This addendum modifies construction documents issued 09-19-2016 and consists of four different types of content:

Addenda

# L2.0

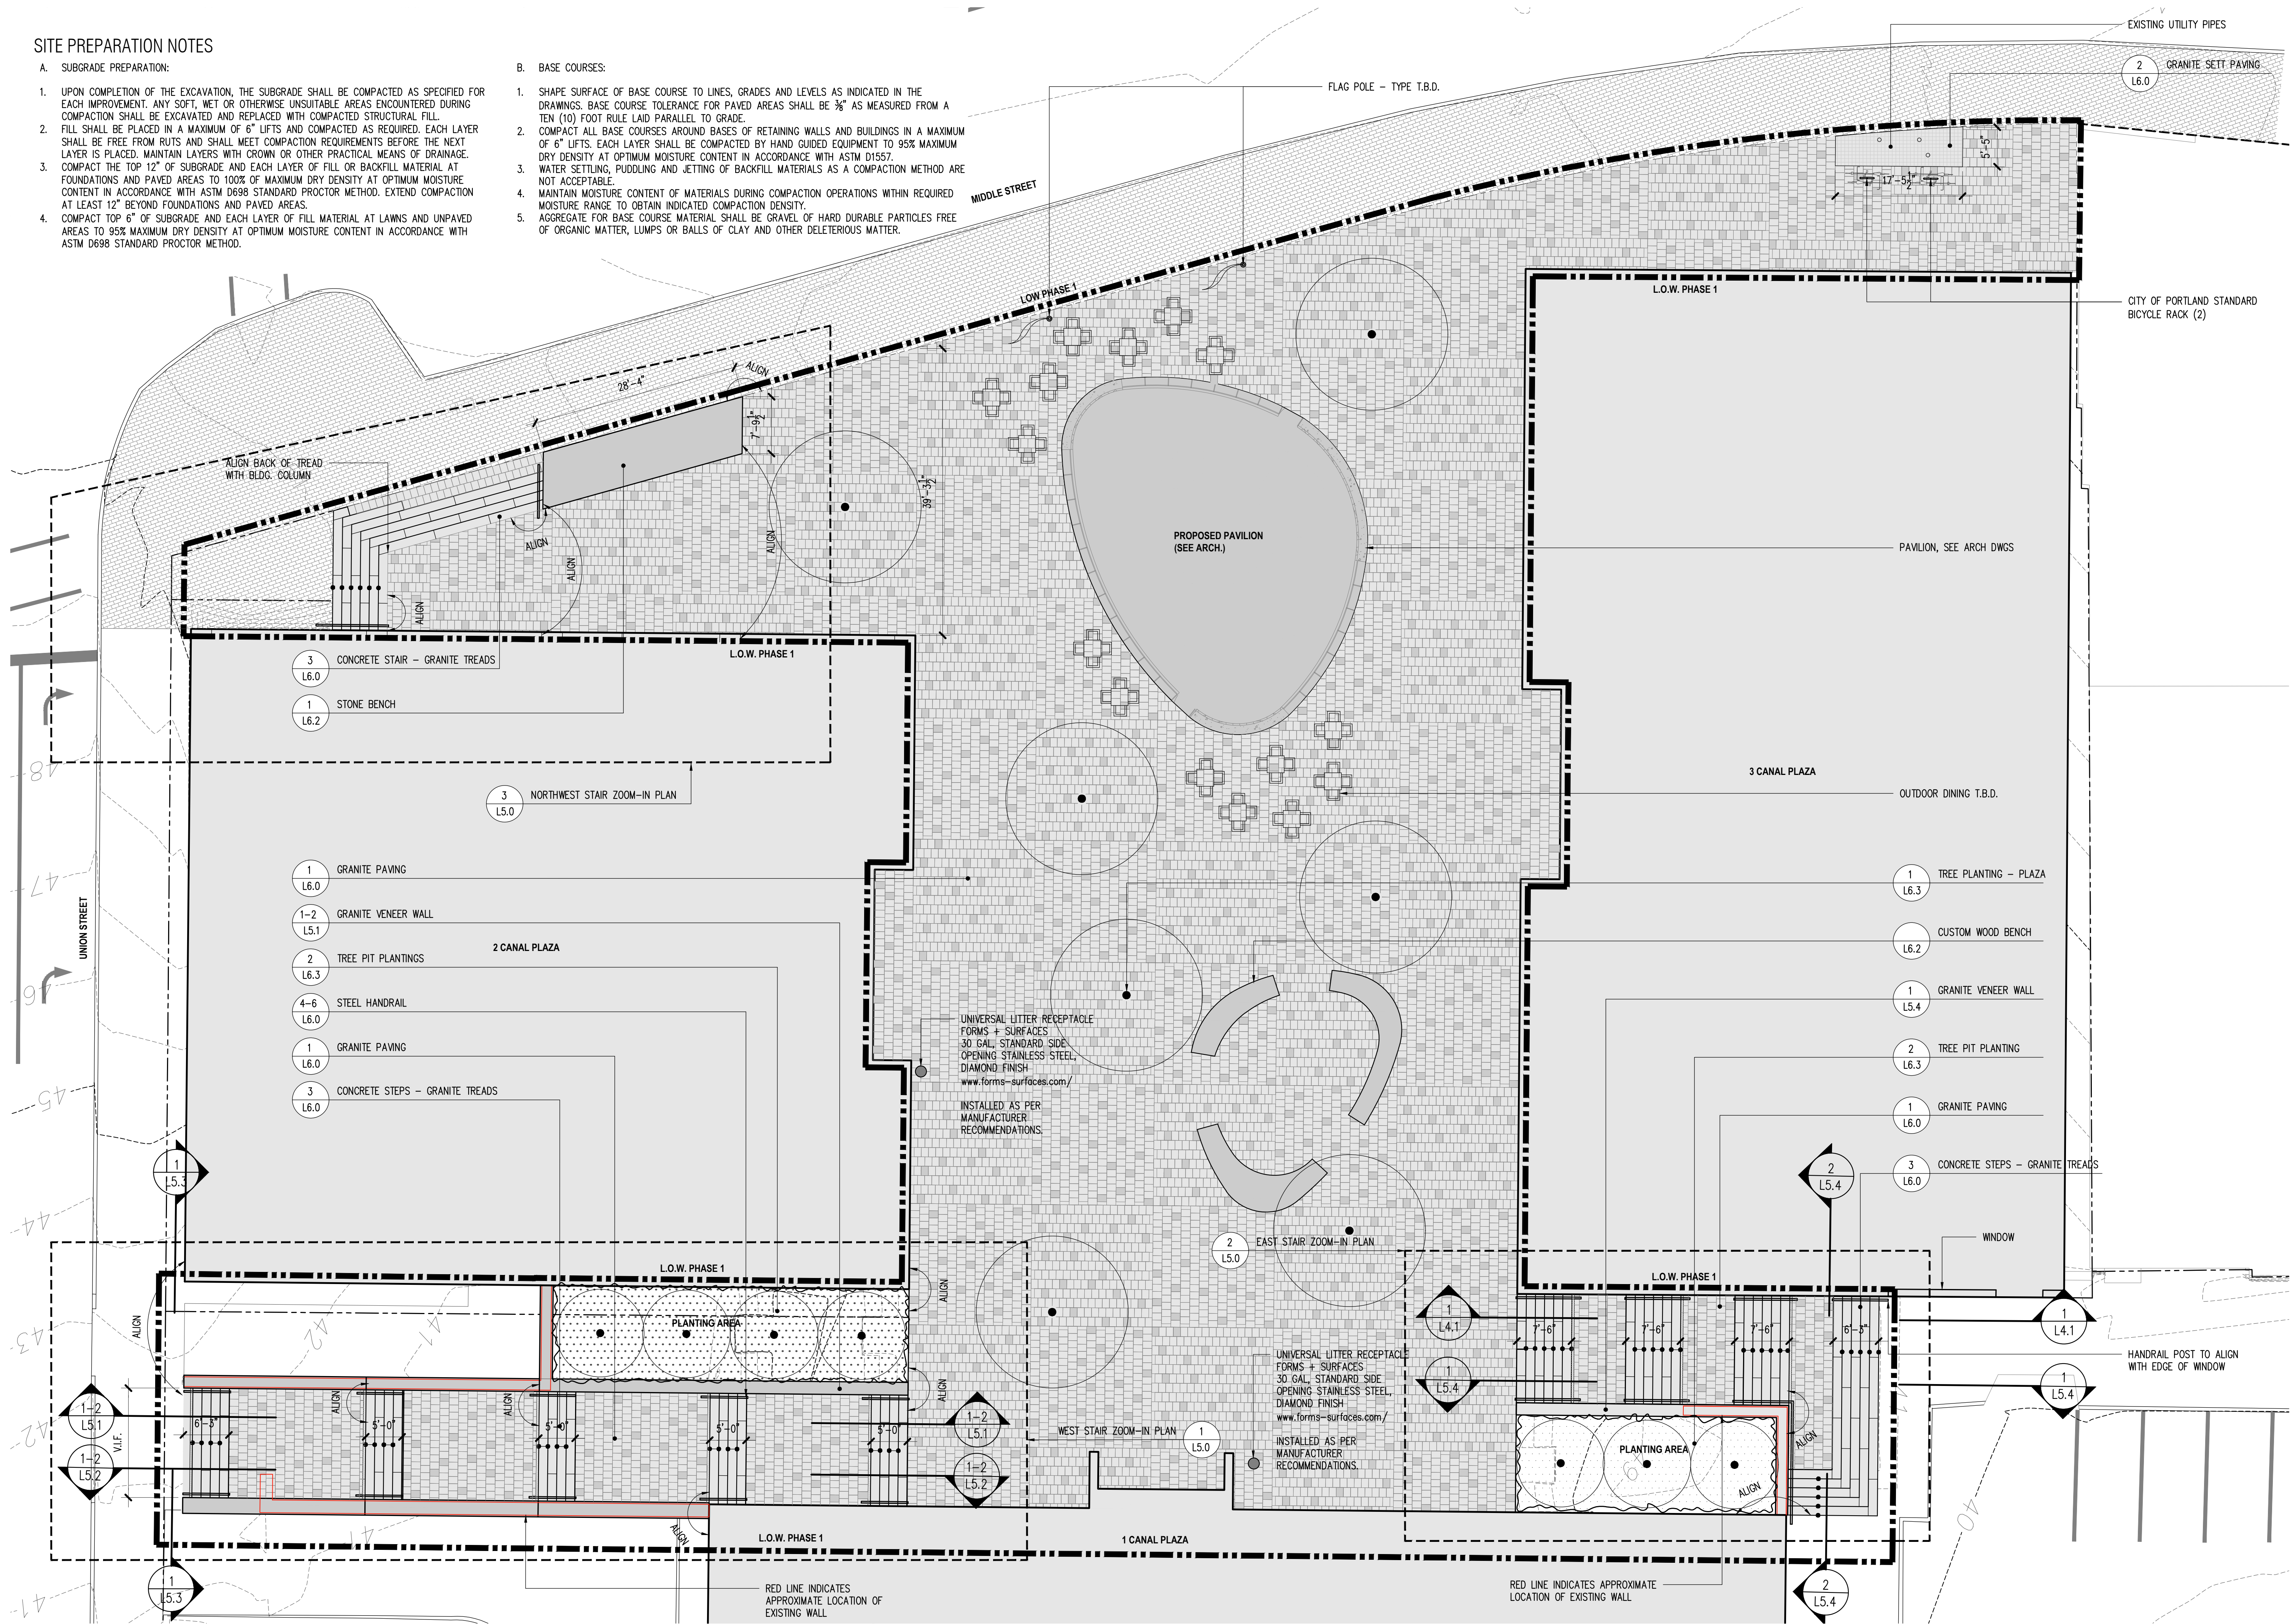
LAND-02	R-SHT	L2.0	Reissued	<ul style="list-style-type: none"> Issued for construction with stamp Added guard rails and detail tags at ends of planters Now only single bike rack and location moved to left of granite setts. Detail tag included. Added detail tag for flag poles Added note to refer to specs for graffiti product for veneer walls Added detail tags for litter receptacles Added detail tag for steel planting ring Added tag to refer to civil drawings for plaza tree planting Added tag to refer to structural on custom wood bench footings
LAND-03	R-SHT	L2.1	Reissued	<ul style="list-style-type: none"> Issued for construction with stamp Added guard rails and detail tags at ends of planters
LAND-04	R-SHT	L3.0	Reissued	<ul style="list-style-type: none"> Issued for construction with stamp Changed planting note to reflect 1200 cu. Ft. of structural soil per plaza tree Removed "DP" note in planter beds only "RA" remains. Rhus aromatica 'Gro-Low' serving as groundcover in planting beds

A10.1

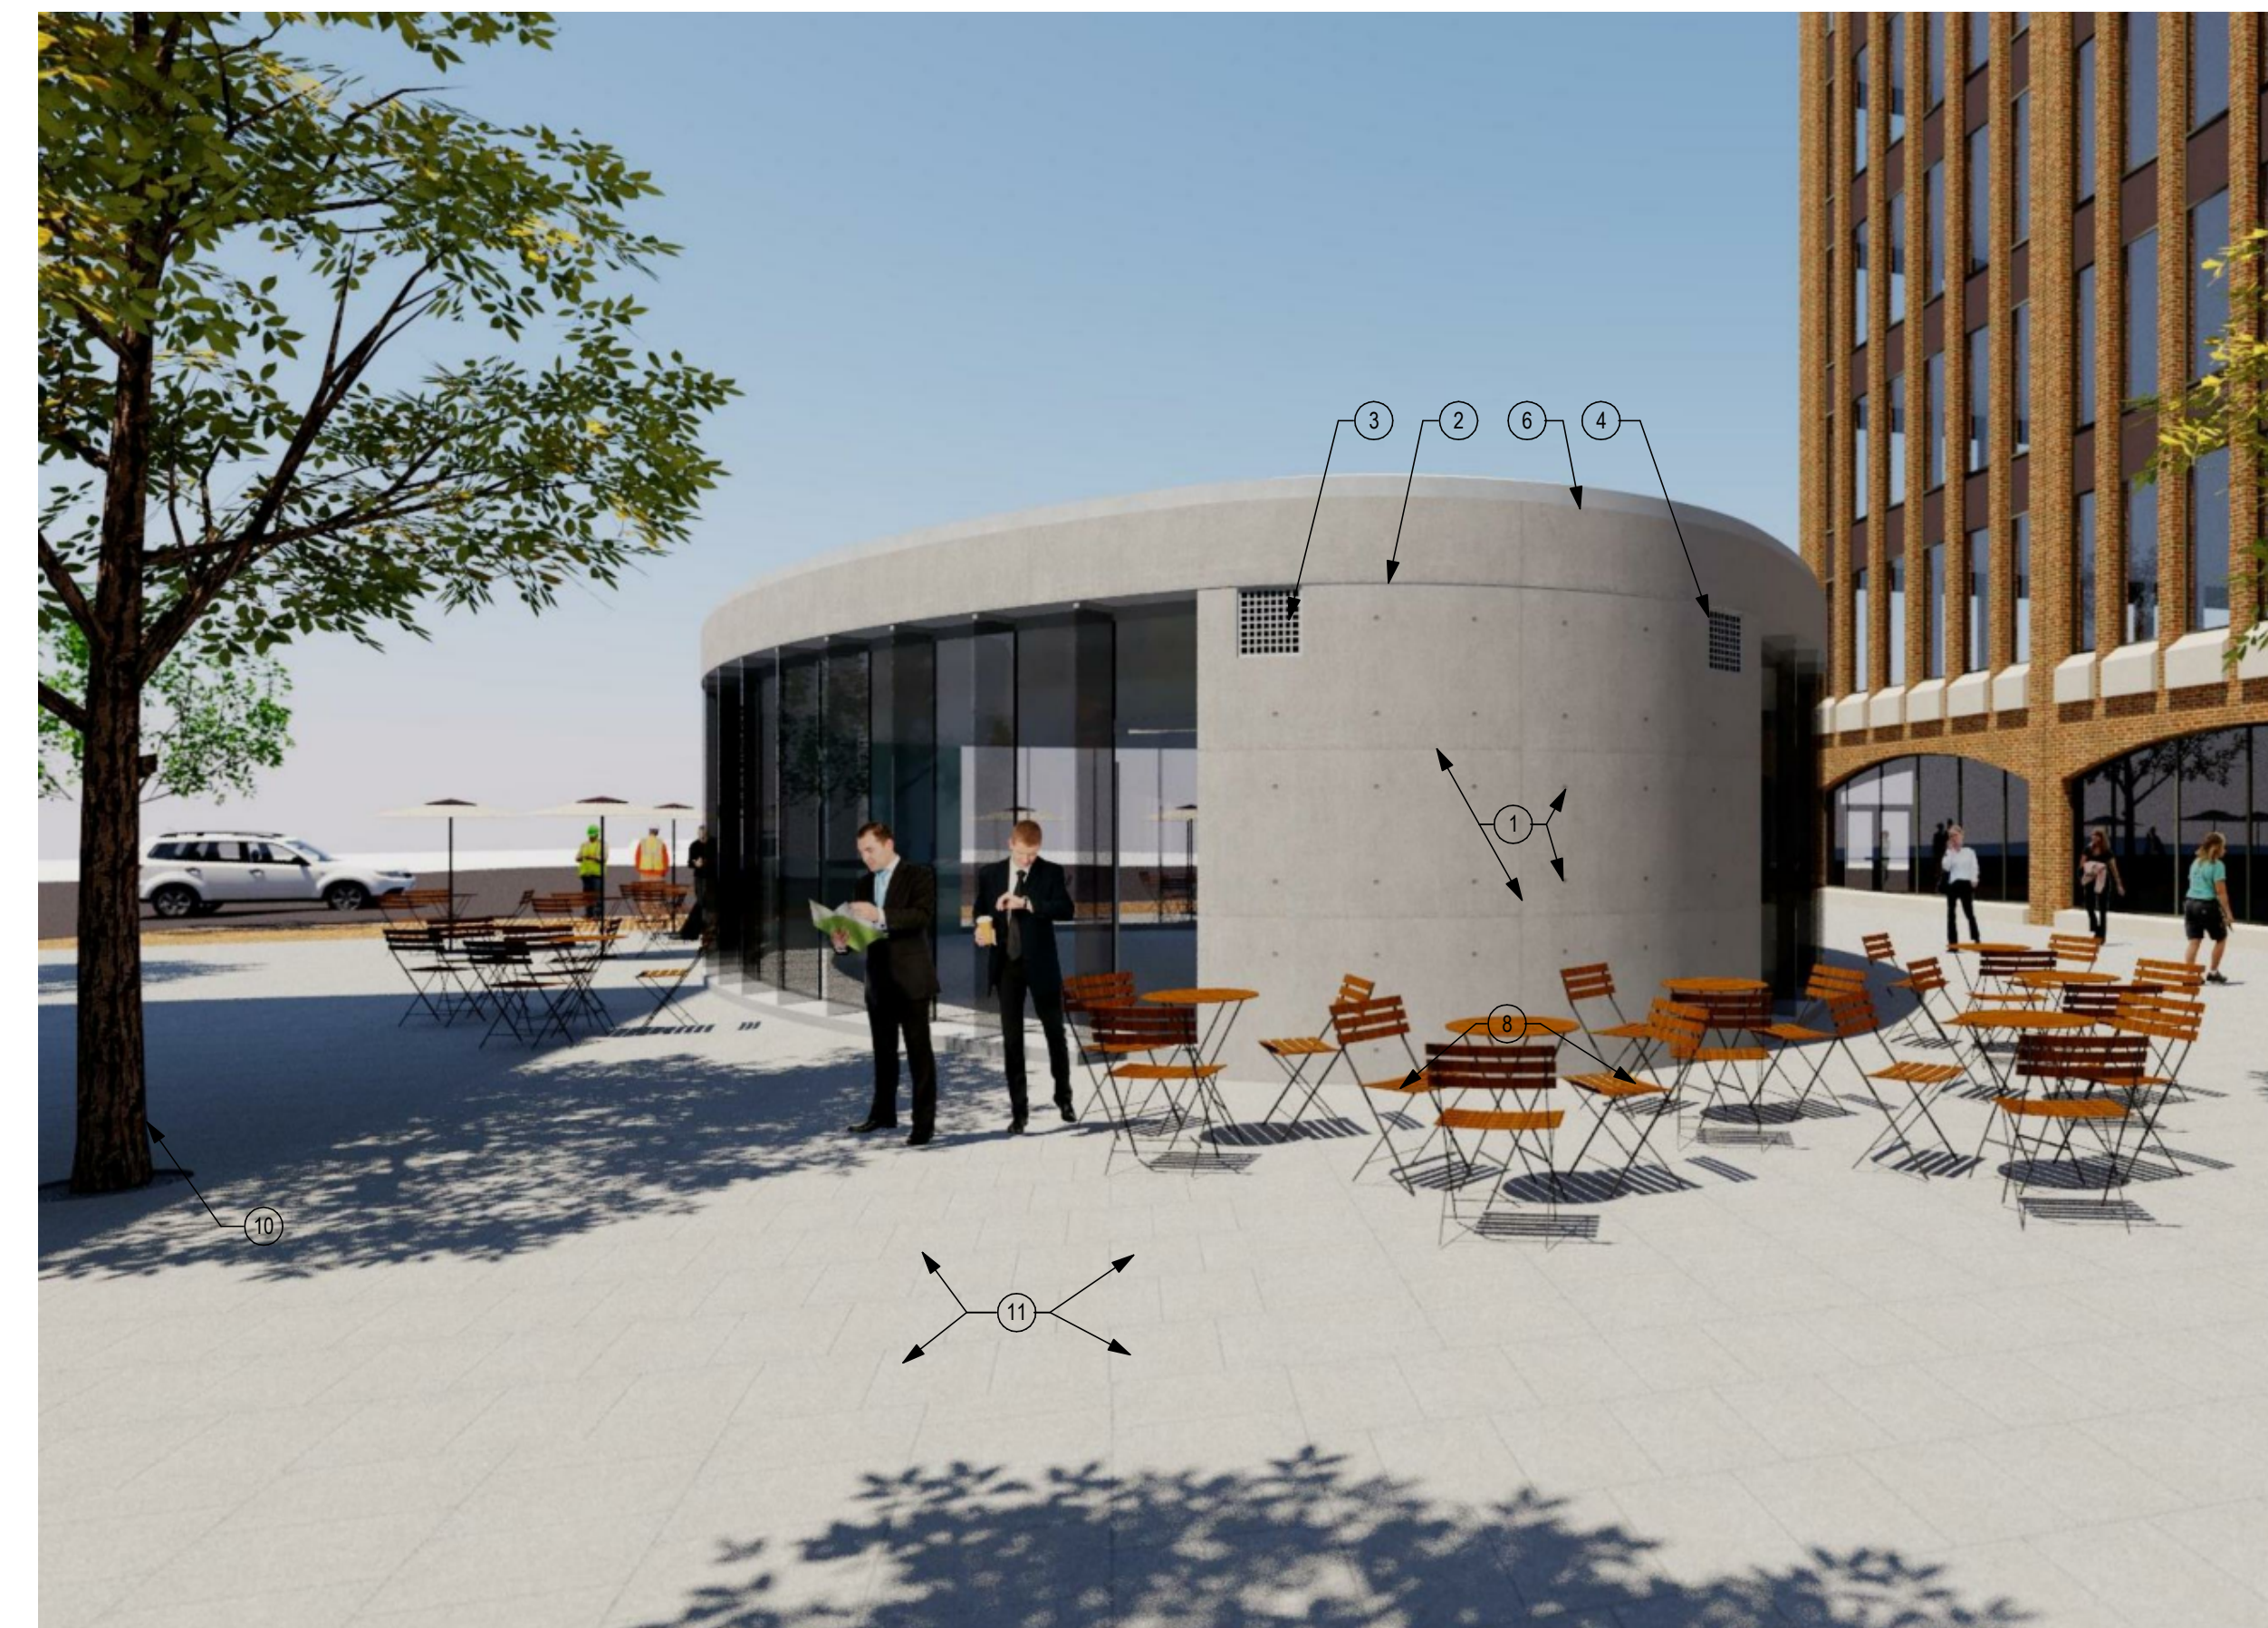
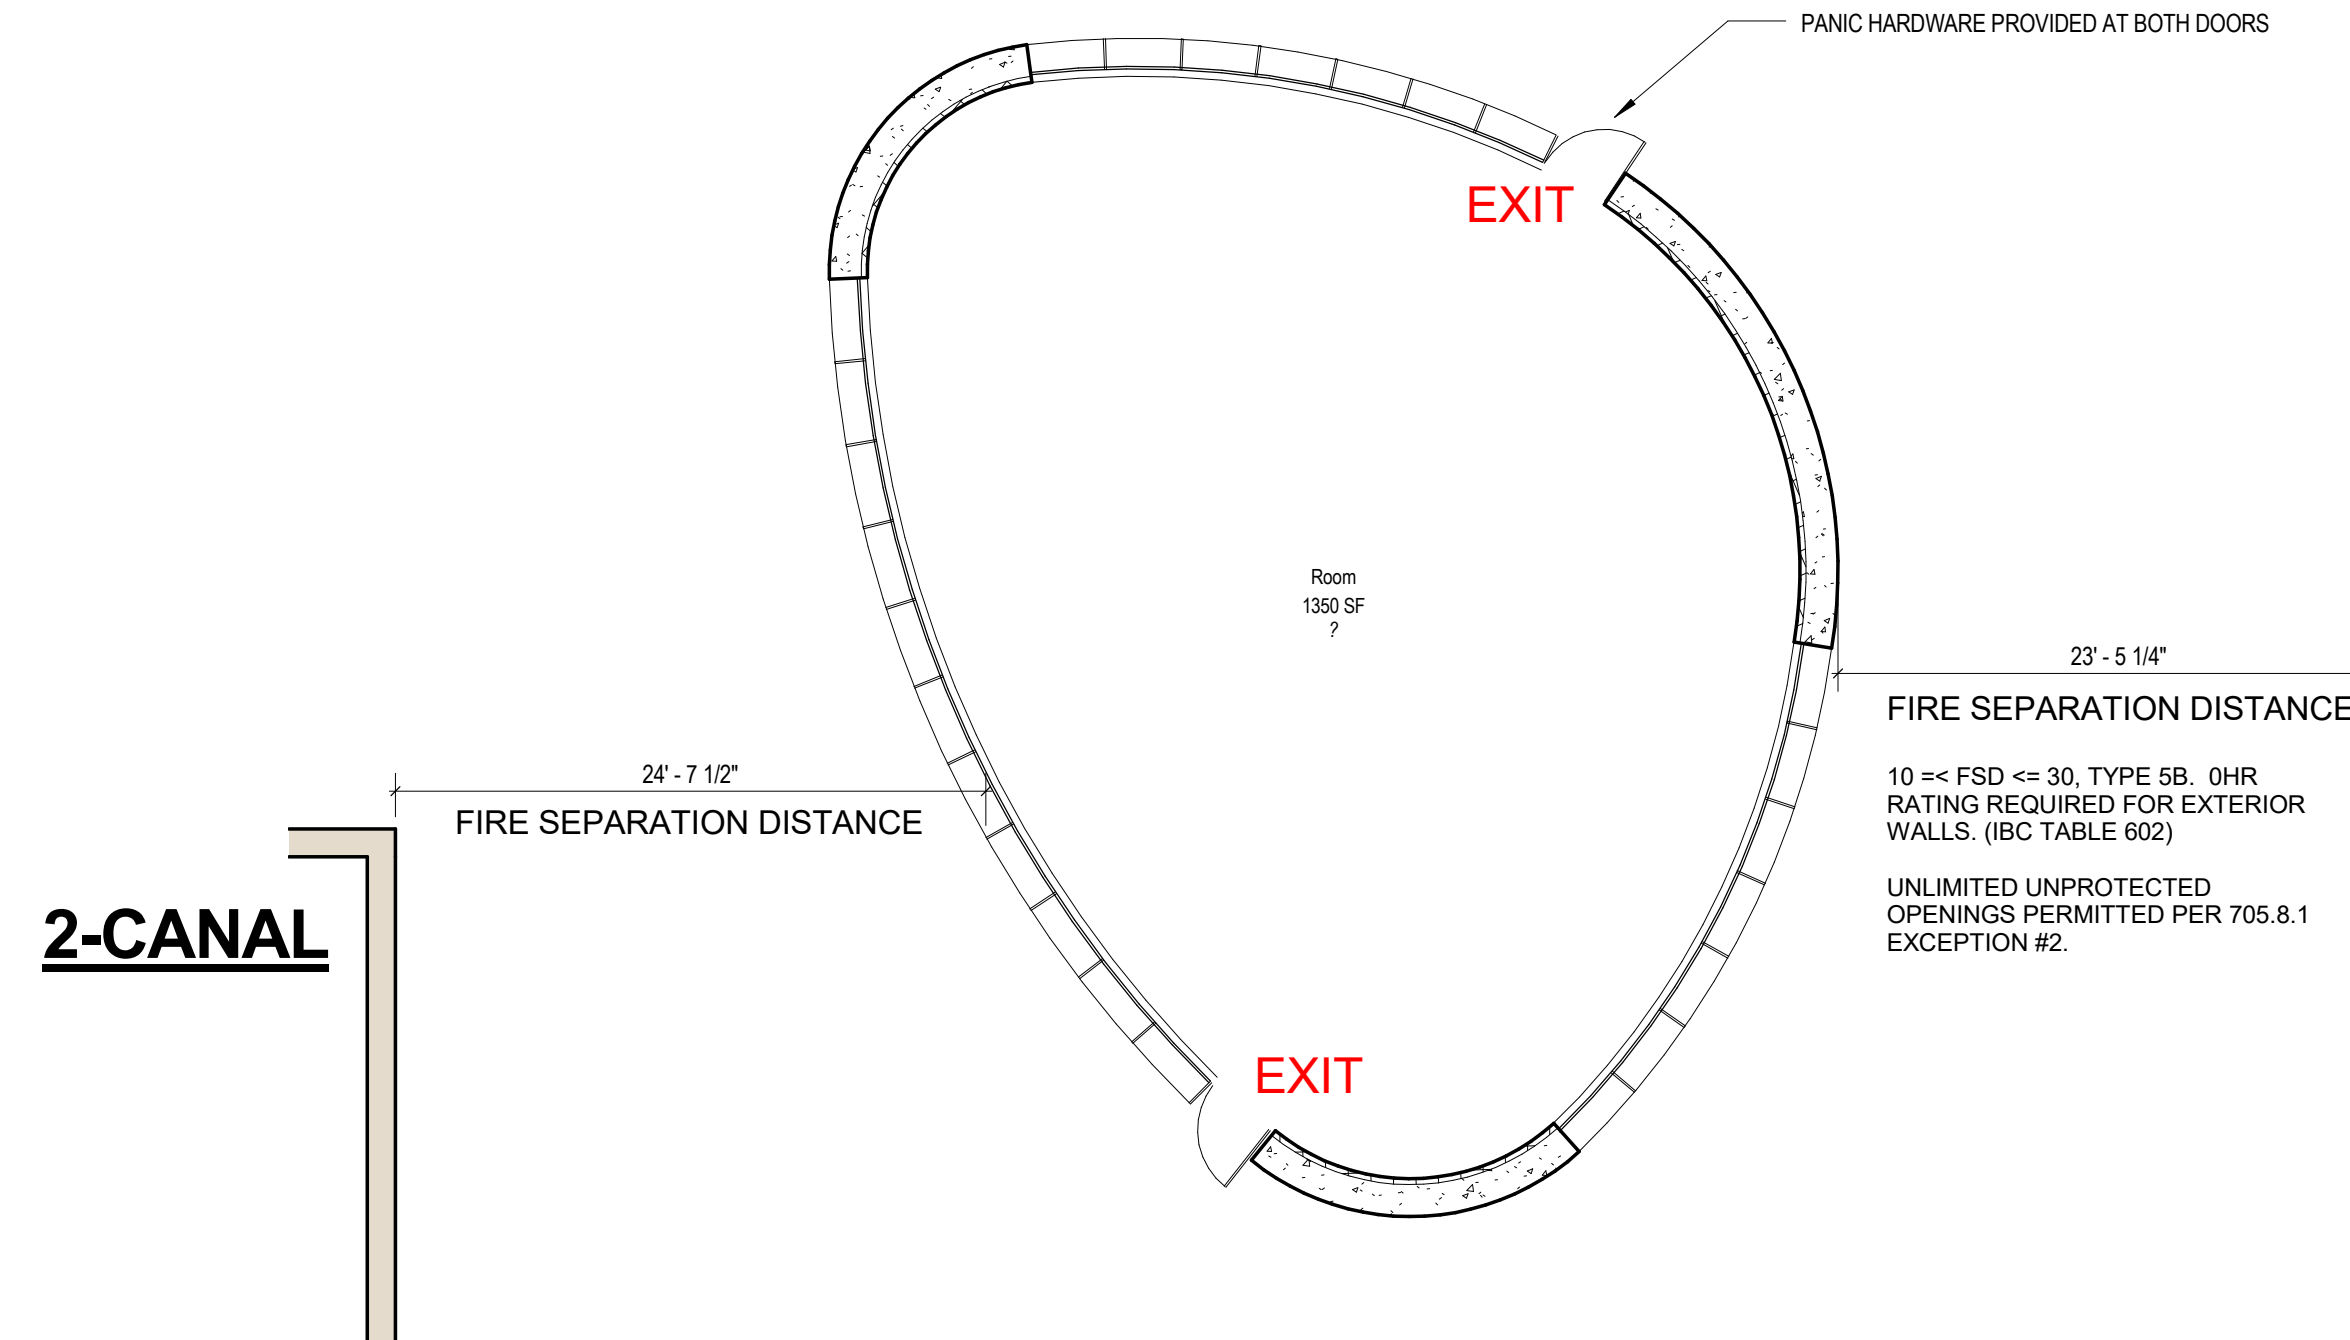
STRUC-10	N-SHT	S3.2	New post tension details sheet.	<ul style="list-style-type: none"> • Added drawing to organize all post-tension details. • Moved PT tendon profiles and details to this drawing from S3.1. • Revised/added details to show both dead and stress ends of PT beams, as well as perimeter tendons. • Added load diagrams to be incorporated into the PT designs
ARCH-01	N	A10.1	Changes to A10.1	<p>Drawing 1/10.1 Floorplan:</p> <ul style="list-style-type: none"> • Keynote #2 identifying concrete bond-outs in concrete wall has been removed. All concrete bond-outs have been removed from walls. • Keynote #2 in keynotes legend should now read "Not used". <p>Drawing 3/A10.1 Roof Plan:</p>

<ul style="list-style-type: none"> Keynote #2 should now read: "ROOF DRAIN - SEE MECHANICAL CUT SHEETS FOR SPECIFICATION. PRECISE LOCATION DETERMINED IN ROOFING / TAPERED INSULATION SHOP DRAWINGS TO BE SUBMITTED TO ARCHITECT FOR REVIEW AND APPROVAL. ROOF DRAIN LOCATION SHOULD BE SET PRIOR TO SLAB POUR IN ORDER TO GET PROPER CONCRETE BOND-OUT LOCATION.
ARCH-02	SK	SK-001	Lighting Bracket Sketch	<ul style="list-style-type: none"> Lighting bracket elevation and details for "theater" type lighting at Canal Plaza building parapets.
ARCH-03	R-SHT	A20.1	Reissued Building Views Drawing	<ul style="list-style-type: none"> Created new concrete wall elevations. Revised building renderings.
ARCH-04	R-SHT	A30.1	Reissued Section Drawings	<ul style="list-style-type: none"> Removed full under-slab insulation. Added "see structural" note regarding slab insulation. Created new detail 7/A30.1 "Planter Grade at Buildings"
